## Fire Marshal Division

**Re: Meredith Square Apartments  
603 Main St.  
Lillington, NC 27546**

**Application Number CFFB18-50044464**

H14 Building Type 1 Life Safety Floor Plan SCALE: 1/8" = 1'-0"

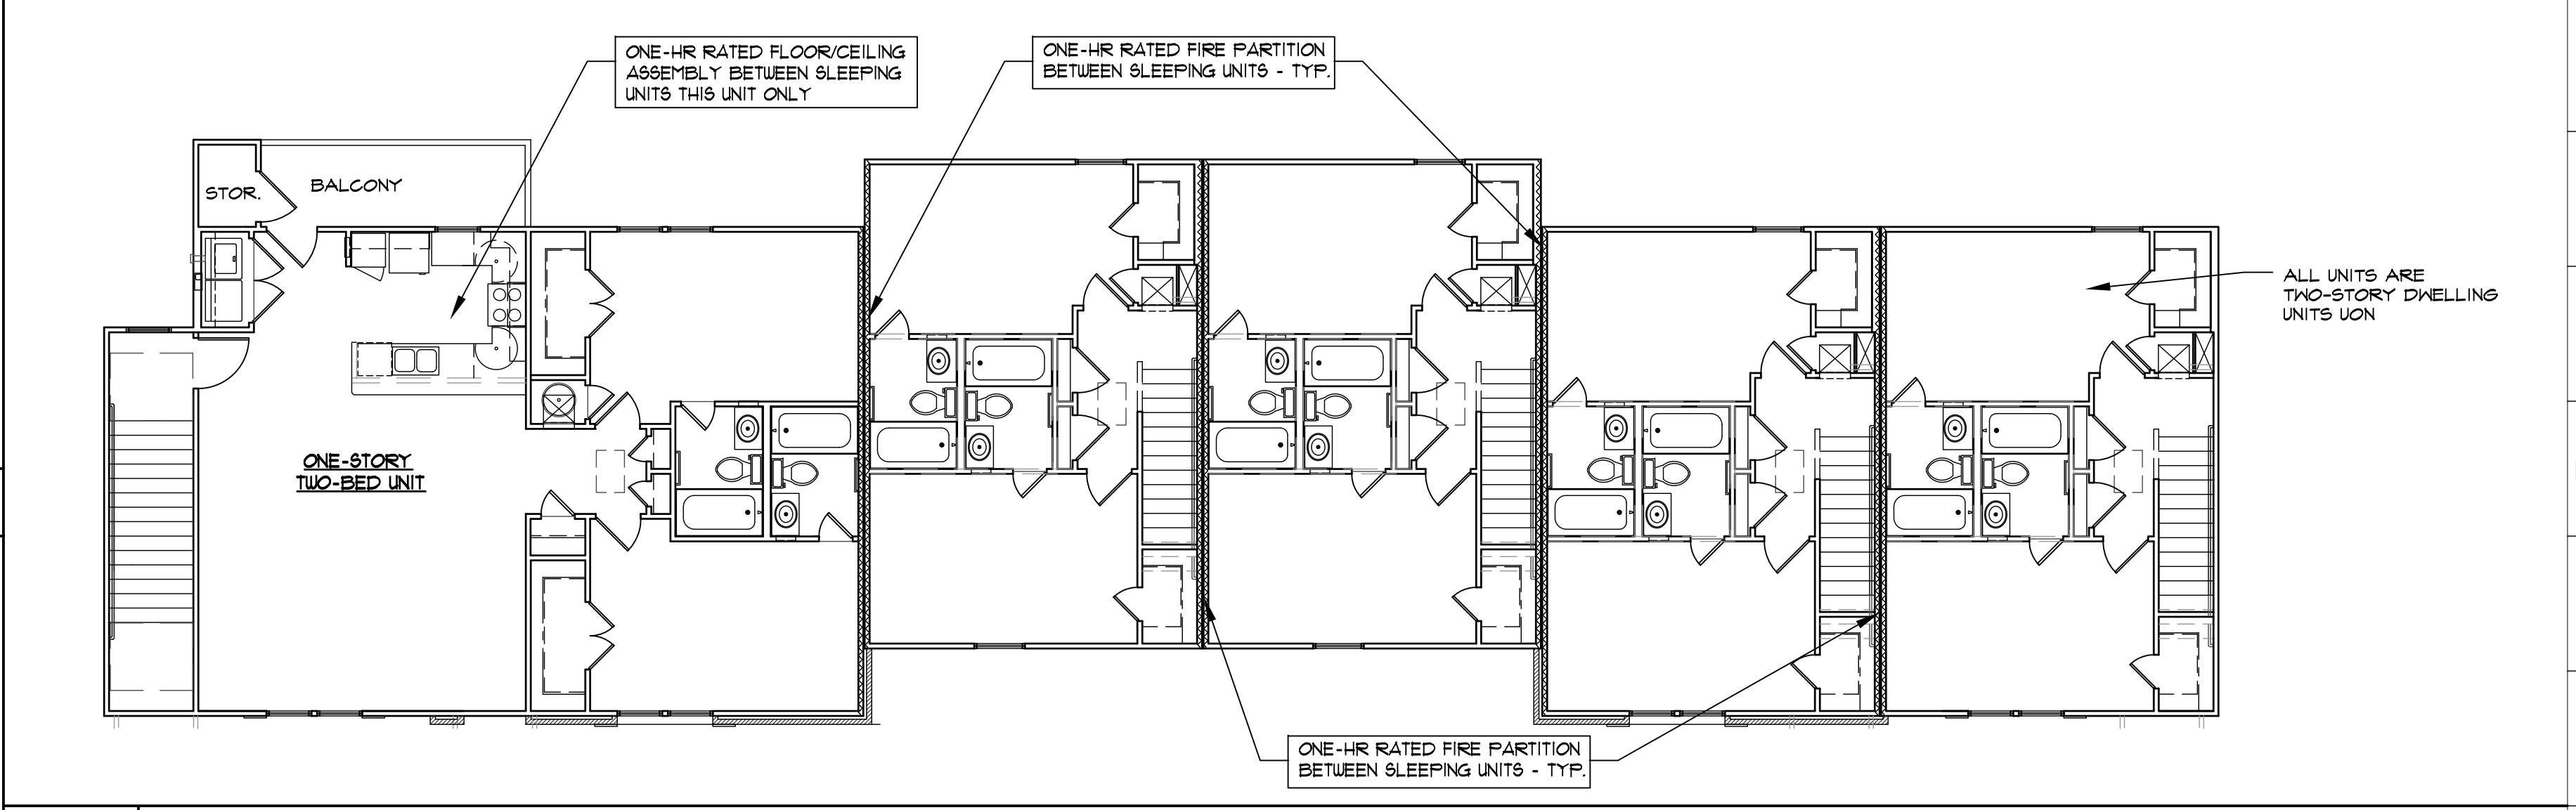
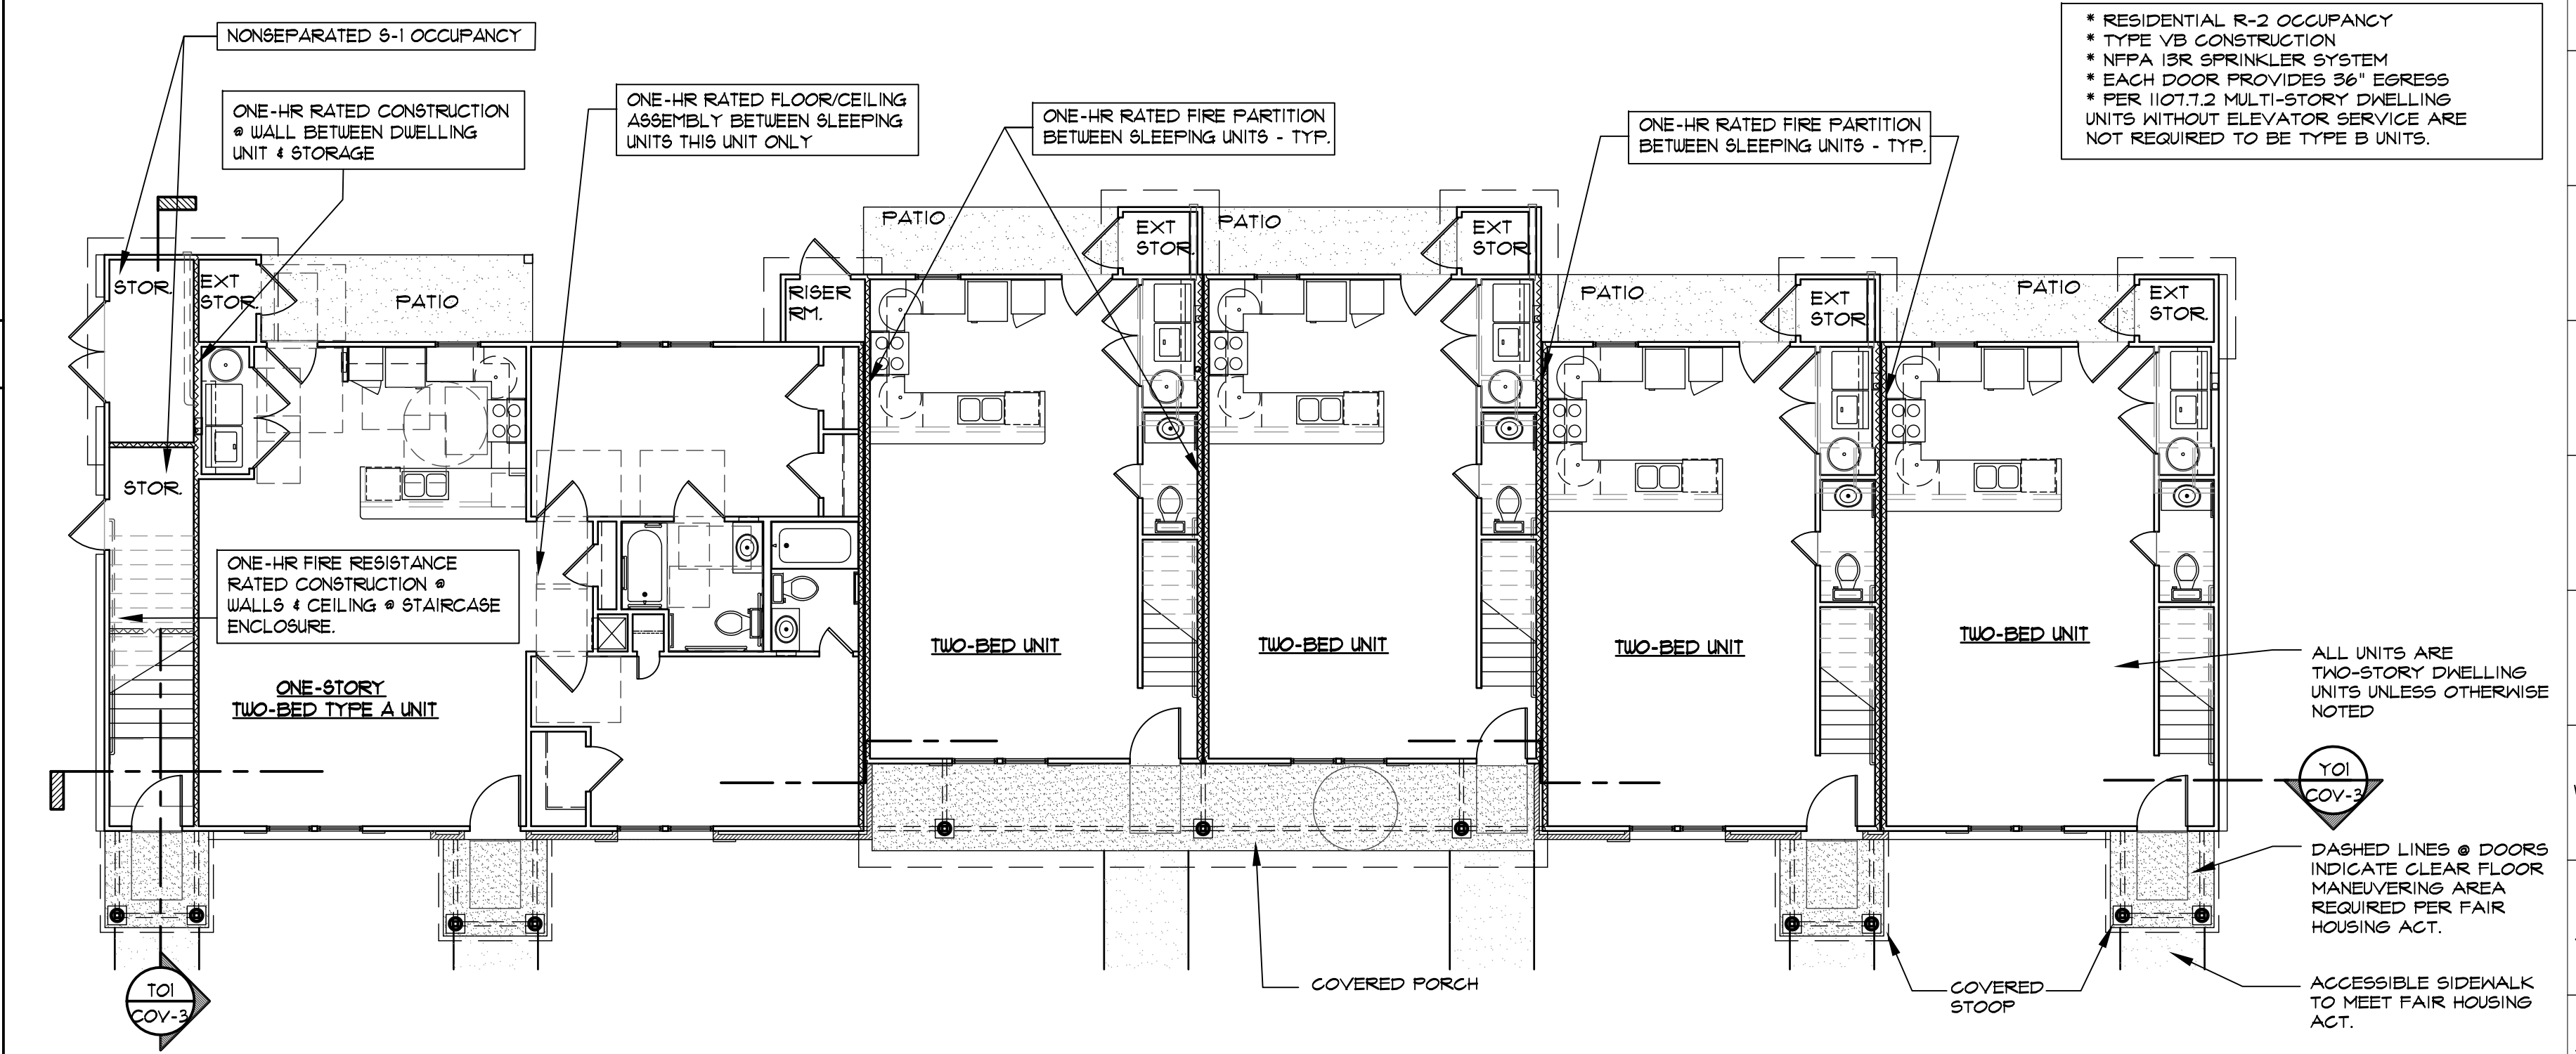
- Details of ceiling height and construction.
  - The interface of fire safety control functions.
  - The current plans include the basic device layout, but does not include the other required information.

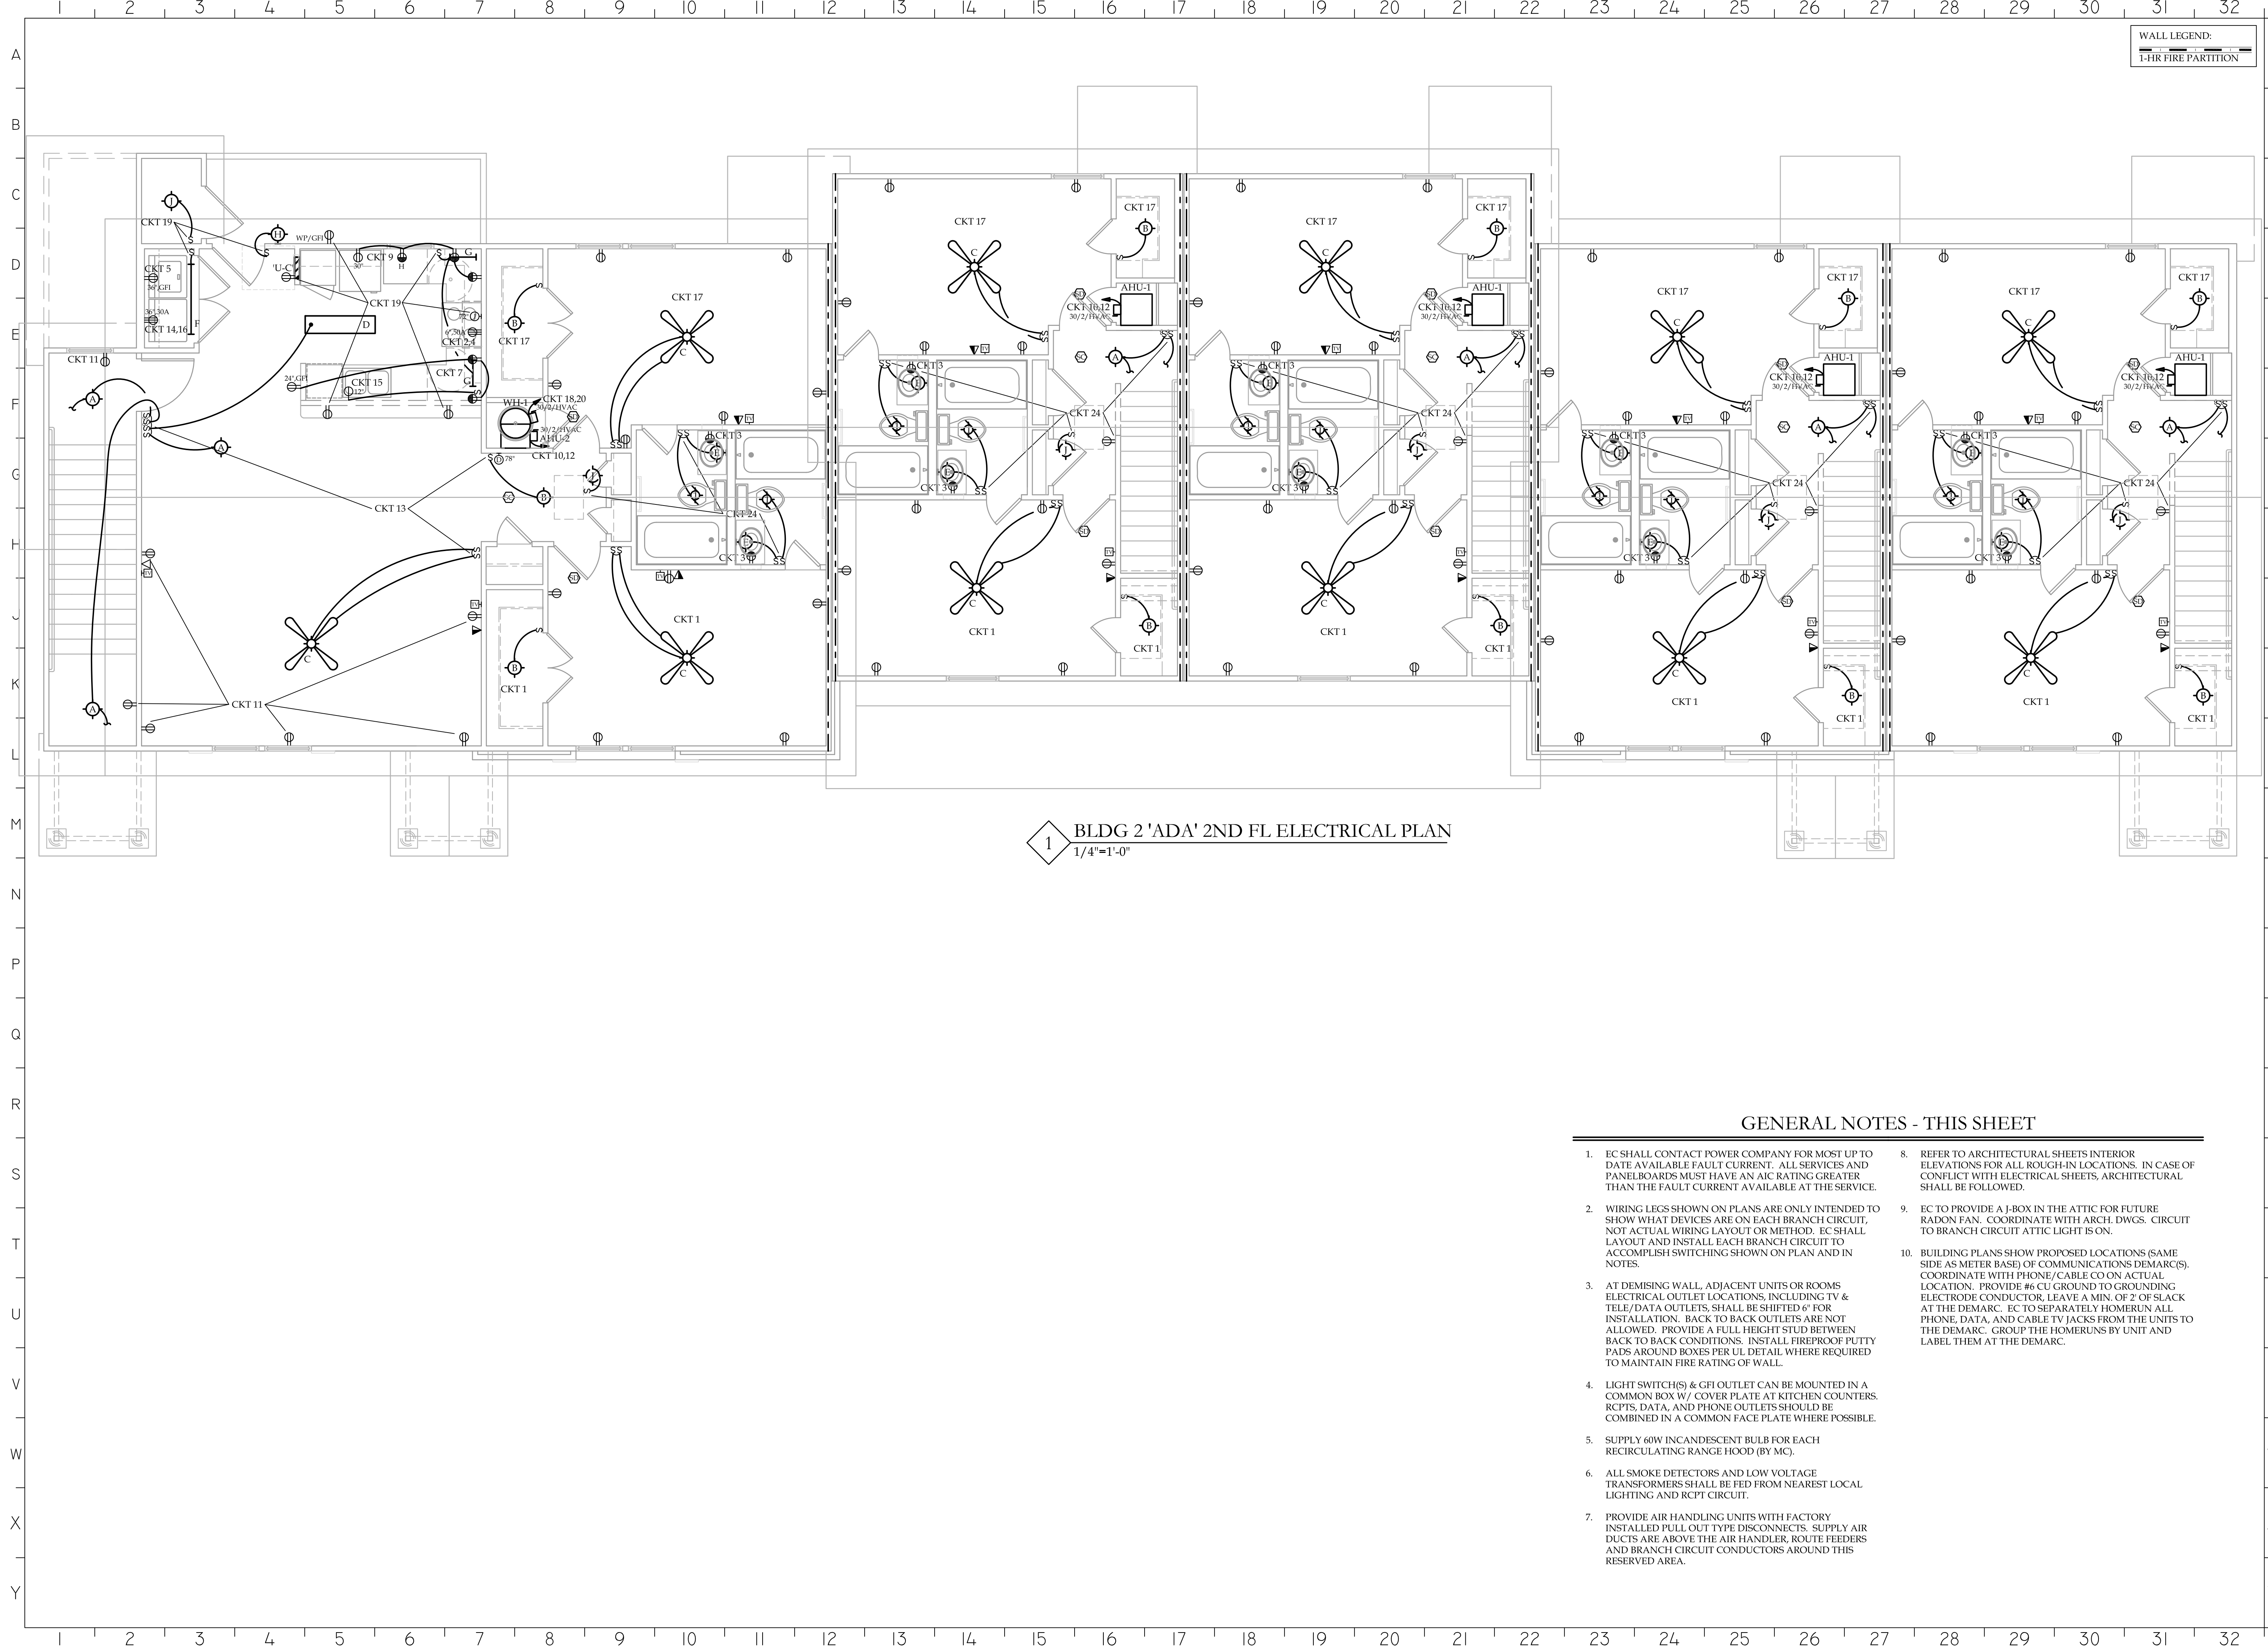
- Please specify the in-consistency in the placement of horns/strobes/horn-strobes on the second and third levels; and the lack of audio/visual devices in some bathrooms/sleeping areas.
- Please call (910) 893-0742 to schedule all inspections.
